**WEST SUSSEX COUNTY COUNCIL
PLANNING SERVICES CONSULTATION**

SUBJECT: LU/140/17/PL - Change of use from light industrial (B1 Business) to van sales (Sui Generis).

LOCATION: Unit 9 Minster Court Business Park, Courtwick Lane, Littlehampton, BN17 7RW.

PARKING PLAN .

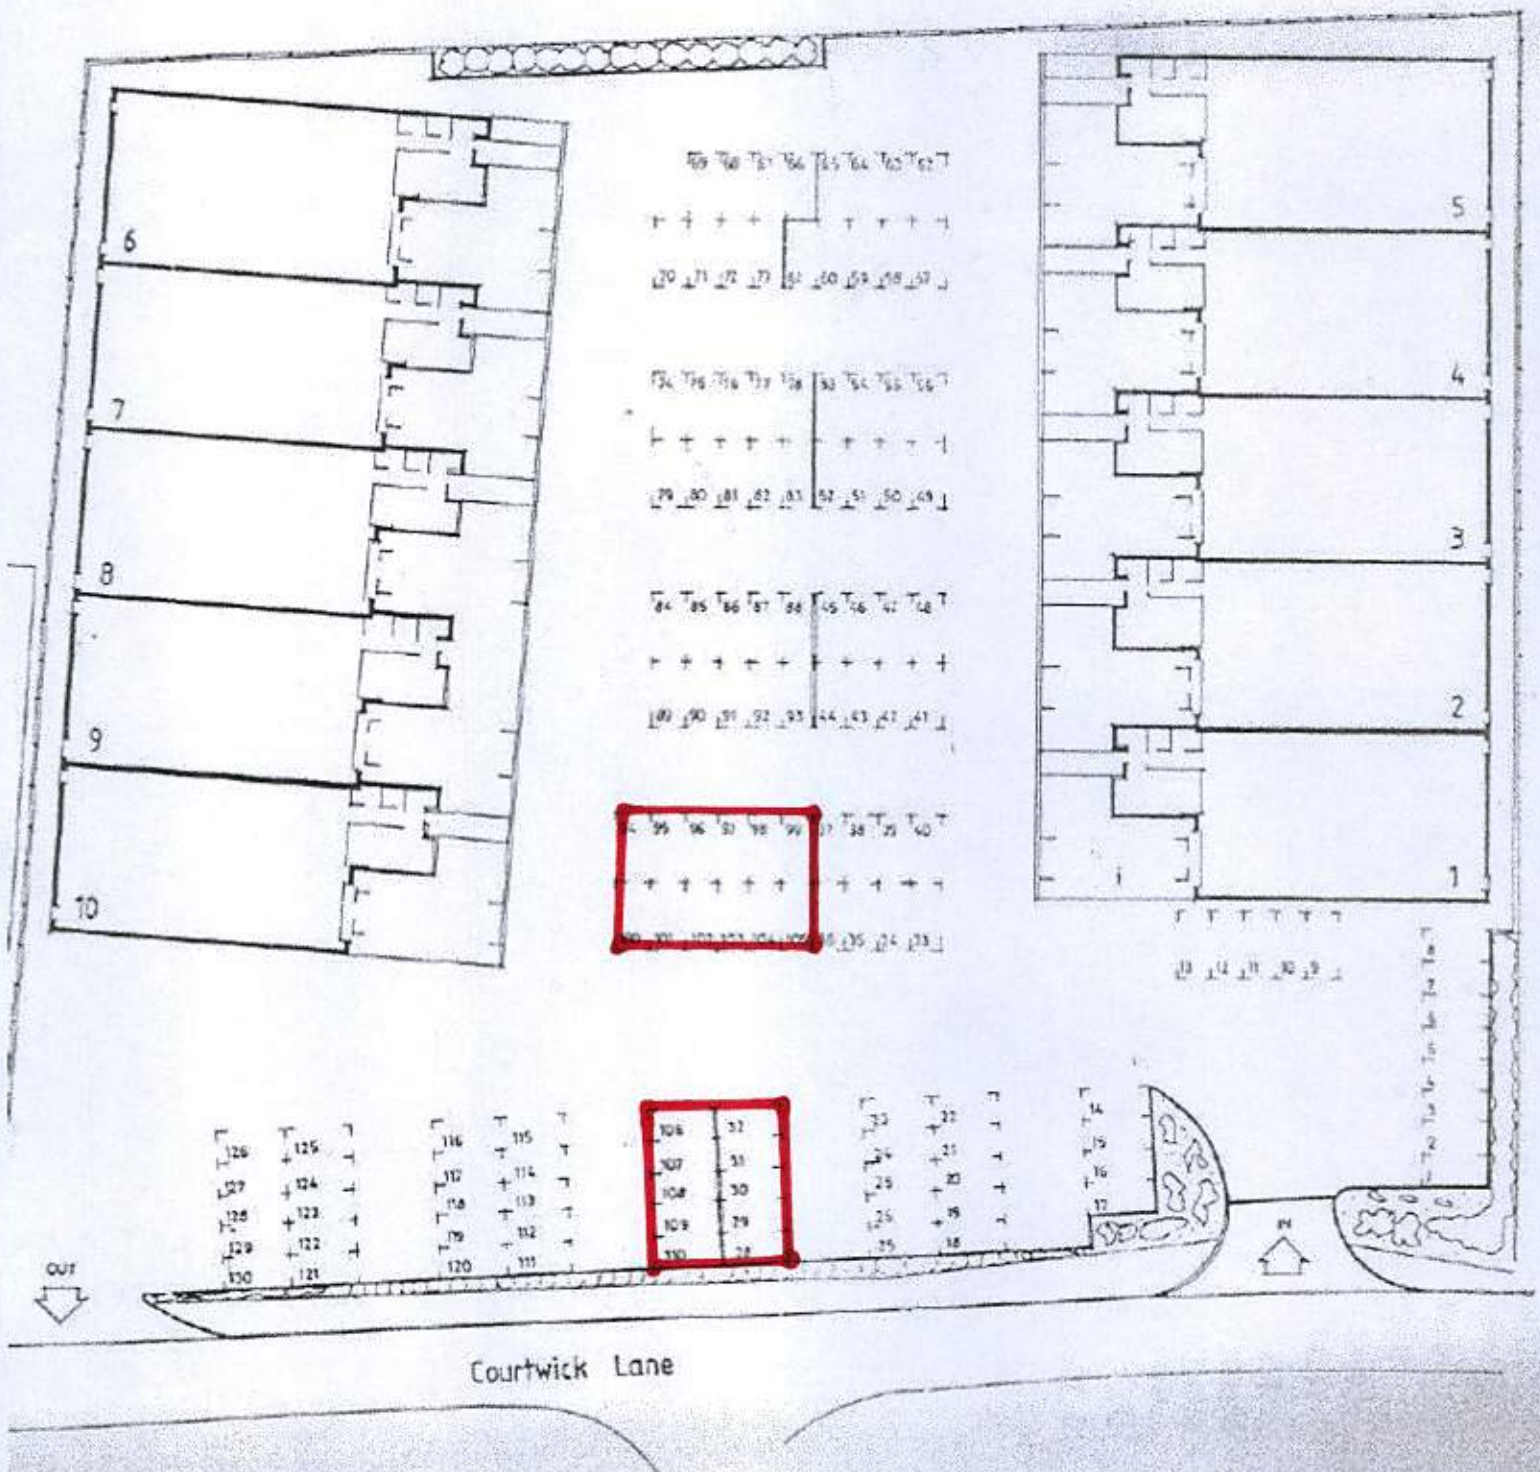
The applicant is seeking COU from B1 Business Use to car sales (Sui Generis) in Unit 9. Earlier drawings supplied by the applicant and those used to appraise the application by the Highway Authority showed that they proposed to use 22 spaces within the overall car park (not including any on-curtilage parking) and these were shown within red edging on the parking plan (No.'s 28-32, 90-99, 100-105 and 106-110). However, the latest information provided in undated email from Gavin Donnelly to Tom Legg (appended to email dated 12th September 2017 from Stephen Legg to Anita Gardner, Tom Legg and Gavin Donnelly) refers to parking spaces 18-32 and 106-100 as those being allocated and shown on an accompanying plan edged in red. The email then also refers to parking spaces 28-32 and 110-116, albeit with additional reference to those latter spaces being made available on a 'licence' basis whereby they could be removed at short notice.

Firstly the plans are not of sufficient quality to accurately determine what spaces are which and how many are proposed to be provided. Secondly, concern is expressed that some of this parking could – at short notice – be removed from the applicant, thereby reducing what he/they have available to them. Finally, the email does not fully answer all the questions posed by the Highway Authority in its response to the LPA of 19th July 2017 – particularly where it asked about details of parking within the building etc.

The CHA require sight of a clearer plan showing parking provision that would be available to the applicant for the life of any COU – including that within the building and on its curtilage (including numbers of parking spaces). This should also be clearly marked for the purposes intended – e.g. display/sales, visitor and staff parking etc. and all within the confines of the Business Park site. Also, written confirmation from the landlord stating that the parking spaces applied for will be made available for specific use by the applicant all the time

the site is used for van sales should be provided. Finally, further explanation about the 'licence' arrangements for some of the parking should be provided.
